CAPITAL CORPORATION

AXIS: STAGE 1A

ACCESS REVIEW

7th May 2013

GROUND FLOOR PLAN

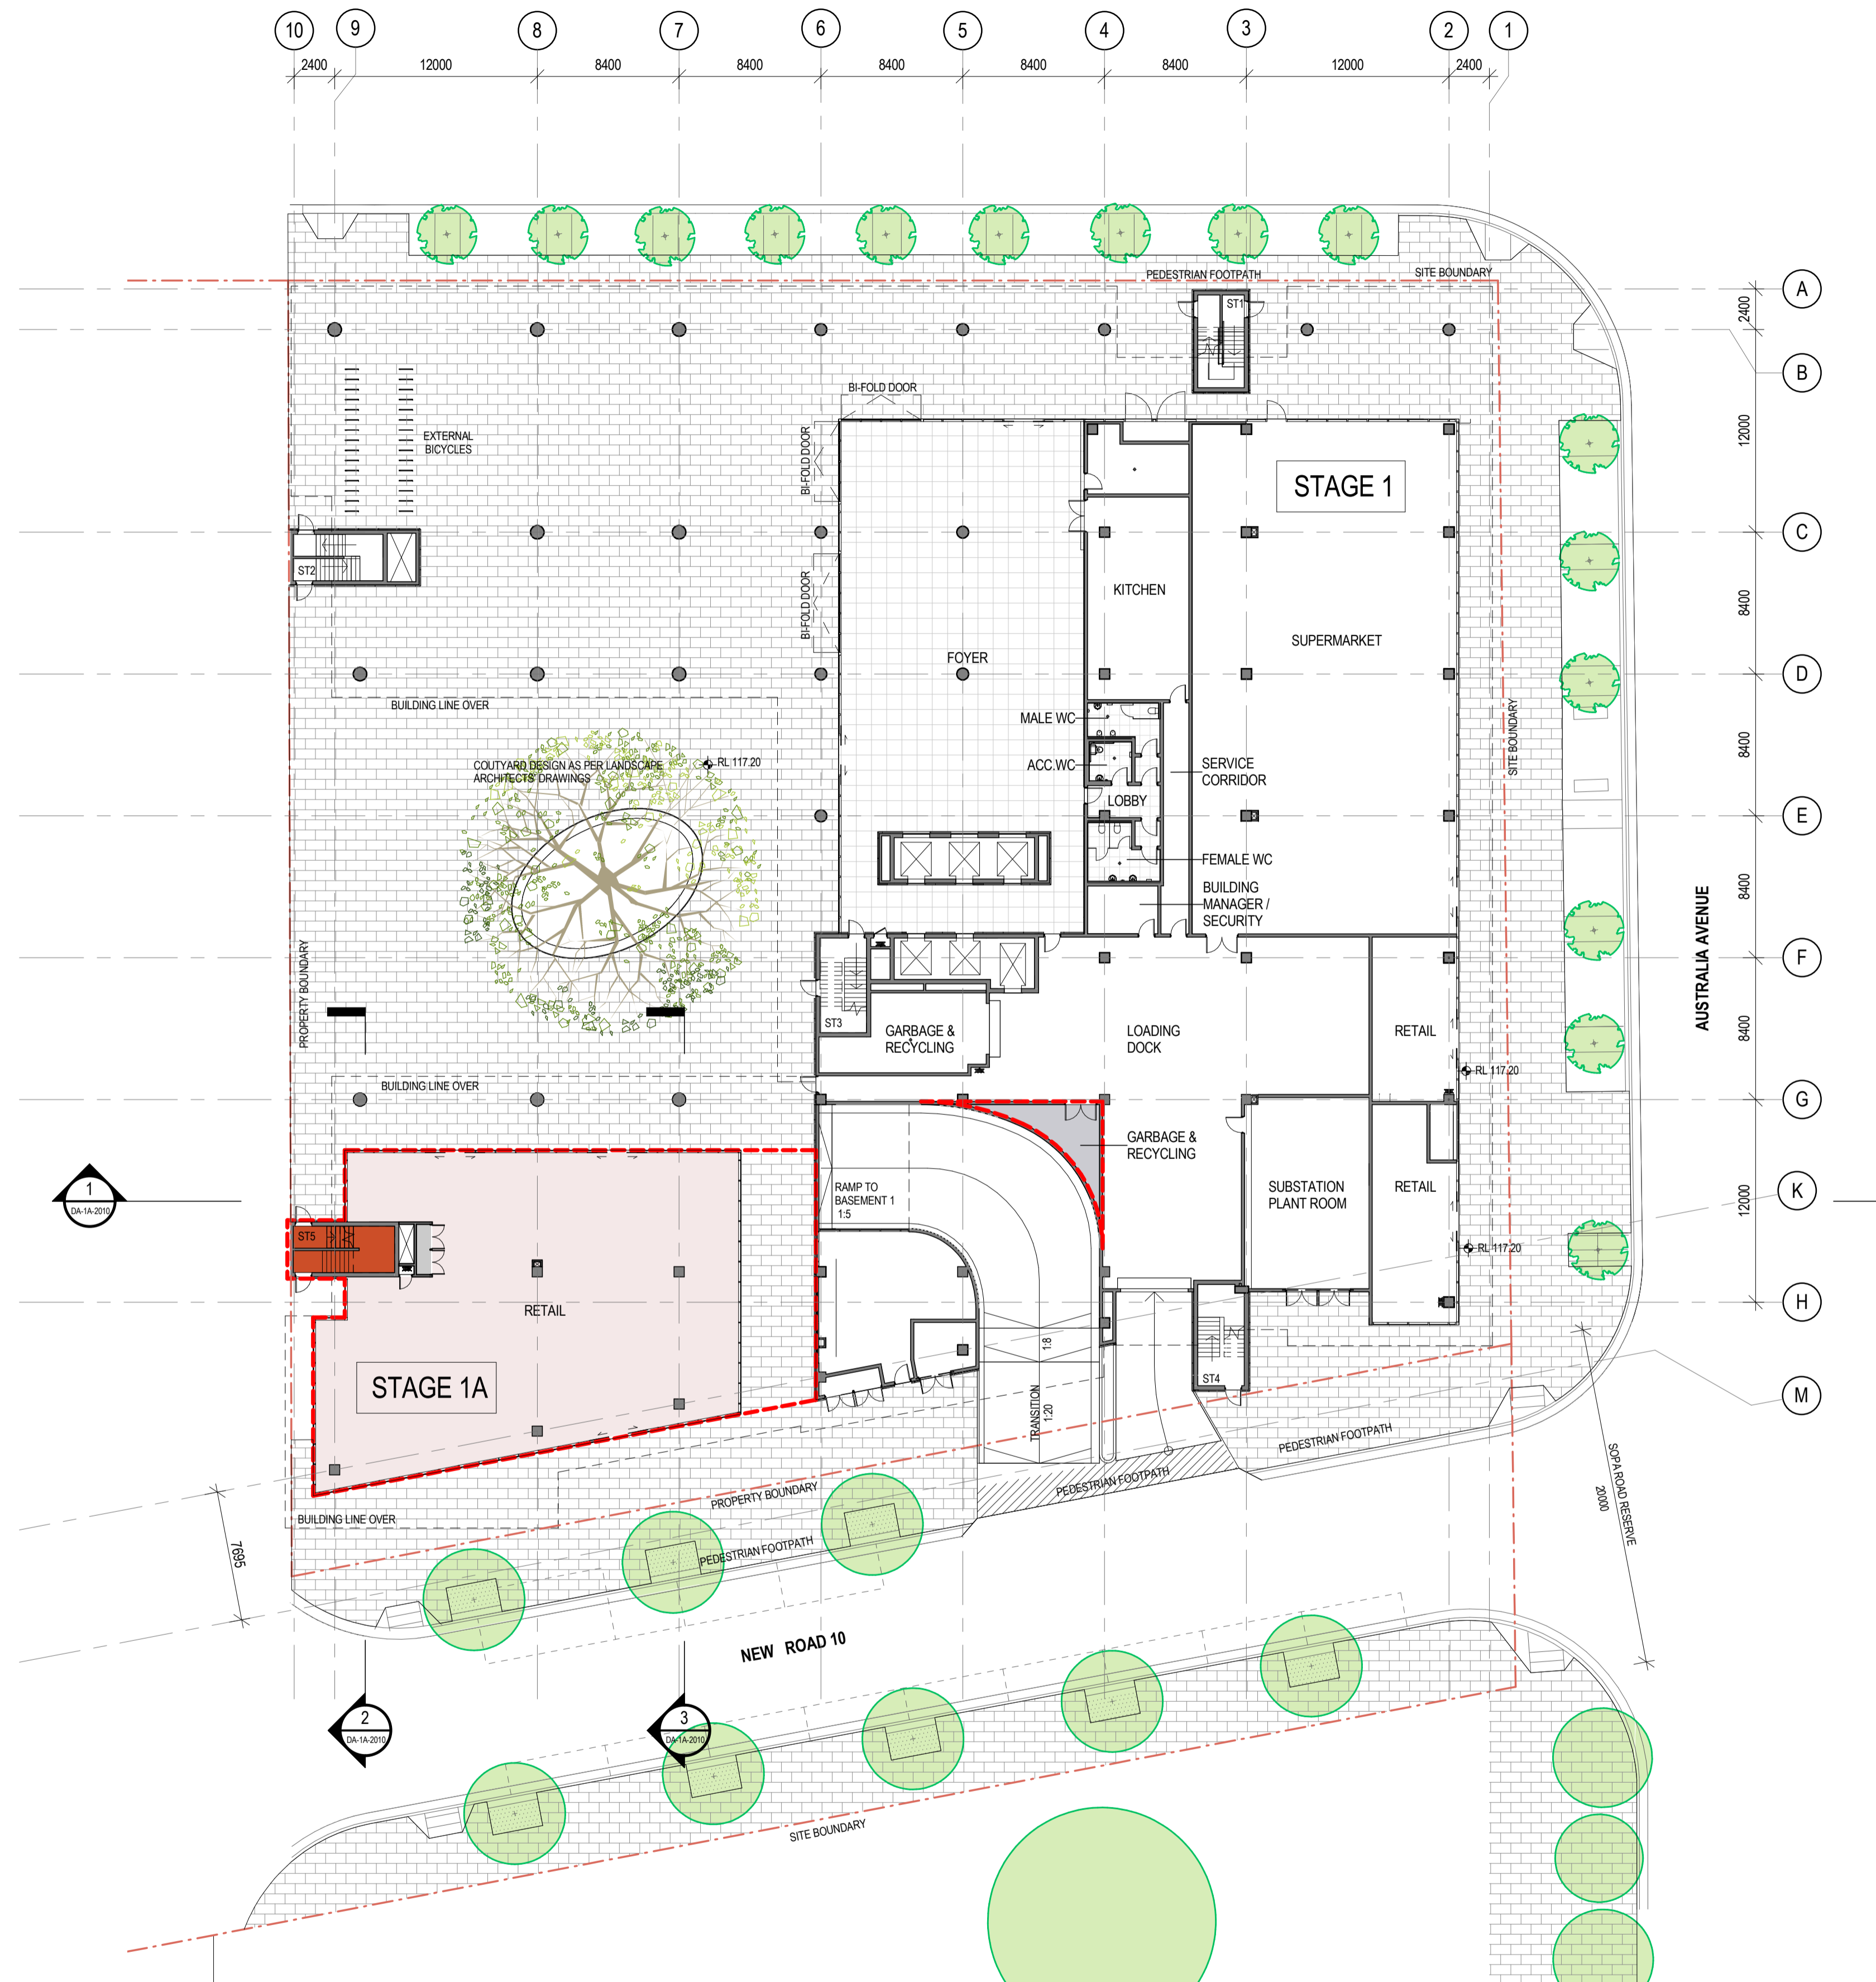
From the ground floor, there are suitable clearances from the pedestrian footpath to the retail tenancy.

A suitable door with appropriate door clearances and circulation is achievable compliant with AS1428.1:2009 and the Sydney Olympic Park Access Guidelines.

- (i) Ensure all retail entry doors have a suitable accessible path of travel with a level landing (i.e. gradient no greater than 1:40) over 1450mm depth compliant with AS1428.1:2009, clause 13.3.
- (ii) Ensure the entry doors have a minimum 850mm clear widths (920 mm door leaf) in accordance with AS1428.1:2009, clause 13.2.

LEVEL 1 PLAN

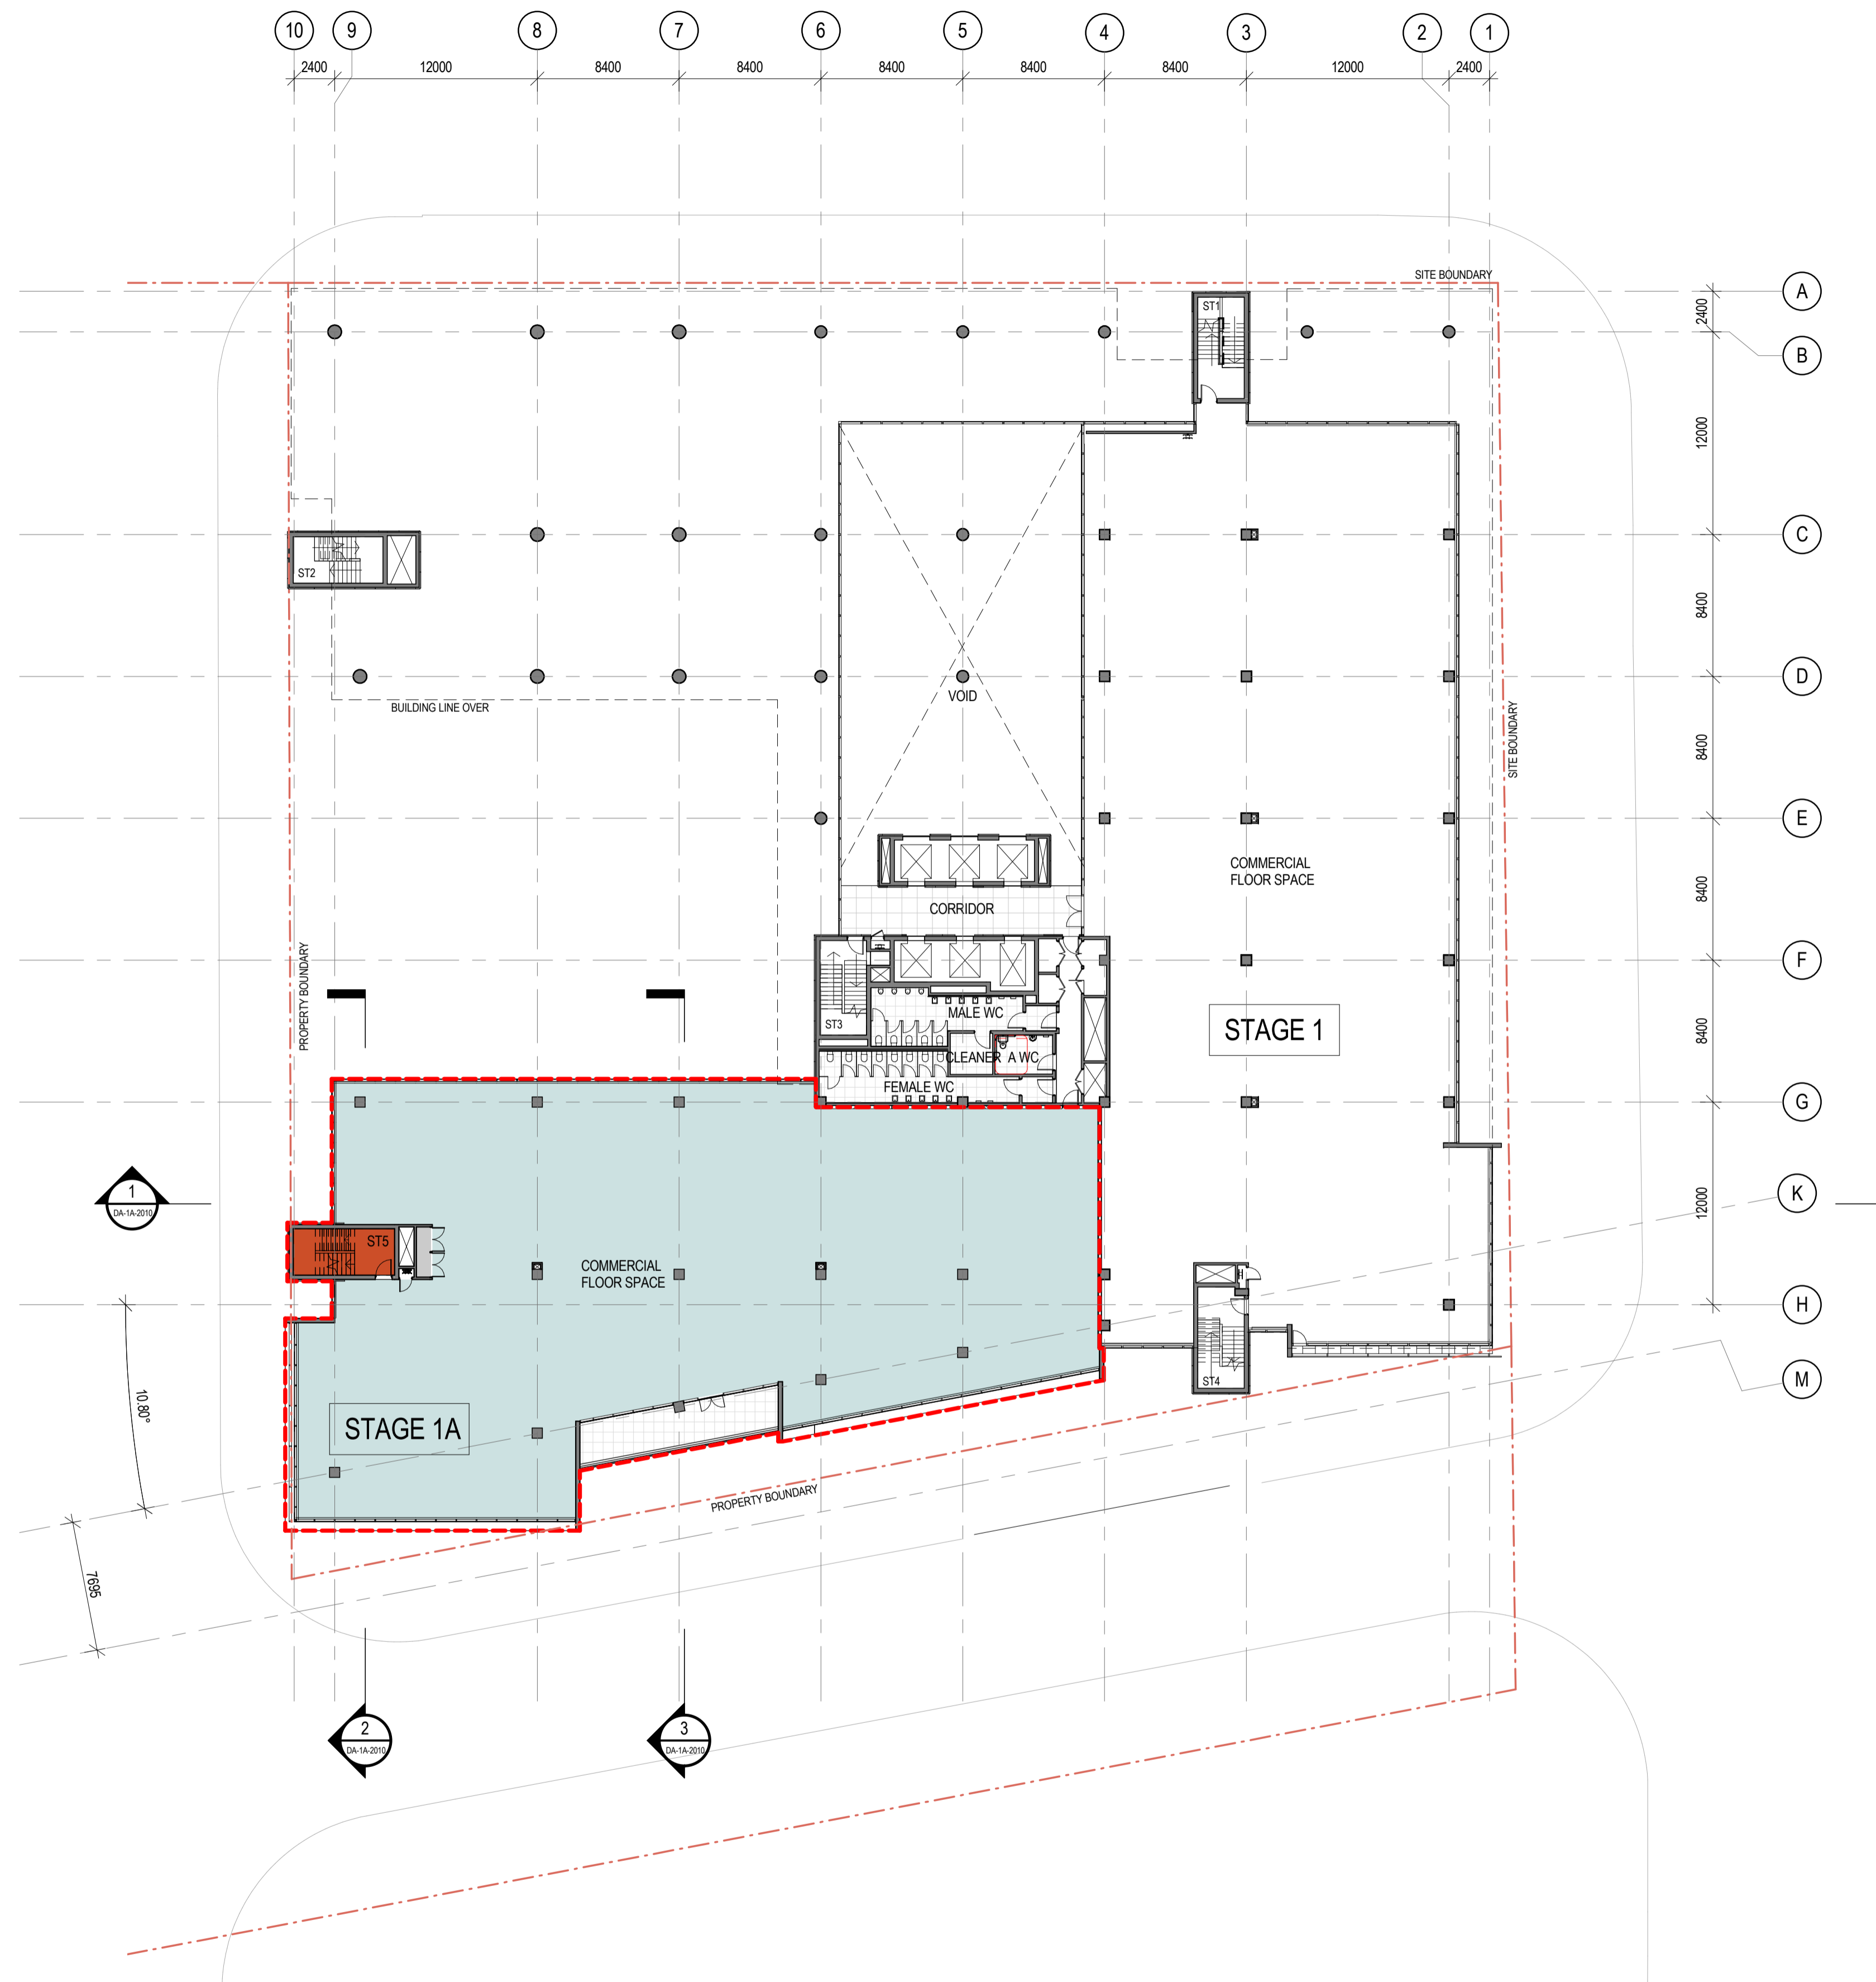
In general, access to the commercial floors (levels 1-7) is via the existing lift core in stage 1. Access from level 1 is currently unclear.

- (i) Provide an accessible path of travel to level 1 commercial floor and all terraces on stage 1A.
- (ii) Ensure dual-hinged entry doors have a minimum 850mm clear width (920mm door leaf), compliant with AS1428.1:2009.
